Our ref: Hastings Secondary College Port Macquarie Campus Upgrade Modification 2 (SSD-11920082-Mod-2)

Following your recent request for additional information, dated 19th December 2022, and referring to the latest modification application for the Hastings Secondary College Port Macquarie Campus Upgrade, Modification 2 (SSD-11920082-Mod-2), please find the following commentary regarding material selection and detailing. Essentially, the original design was complex resulting in a value engineering process that identified the need to change to a light-weight cladding system to ensure the projects viability. The following summary was included in the SSD modification application and outlines the proposed changes.

title
Facade Types
Facade - CAPA

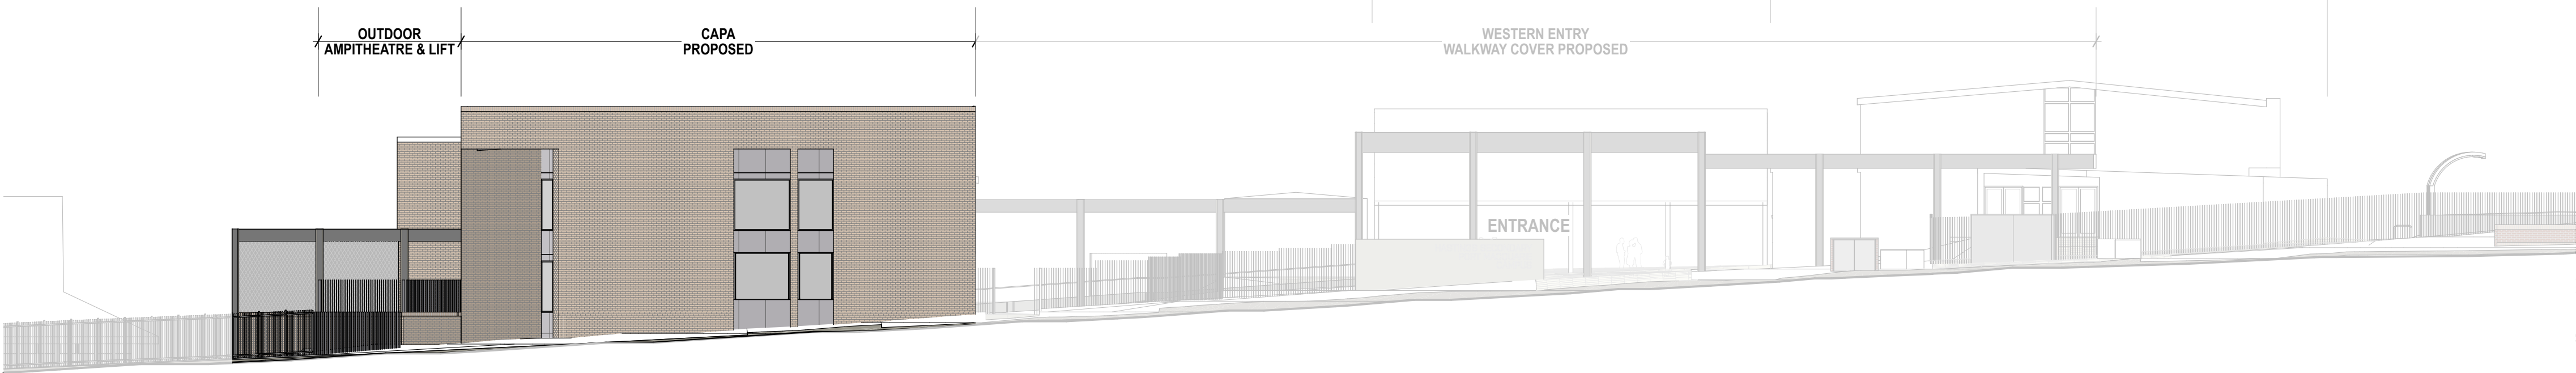
The materiality of the eastern and western facades (Owen Street and Oxley Oval) have been changed from brickwork to pre-finished and coloured fibre cement sheeting. The complexity of the stepped, cantilevered brickwork, and resulting ongoing maintenance concerns, meant that the brickwork became prohibitive. The tonal contrast identified by the SDRP has been maintained with four different coloured FC panels being used to retain the undulating pattern. Each of the panels is packed out from the substrate to provide additional shadow play across the façade. Earthy tones have been retained and are similar to the previous colour scheme. The transition to light weight cladding has allowed the façade design to be adjusted slightly to reflect material properties and to emphasise the central, circular window in a more controlled manner.
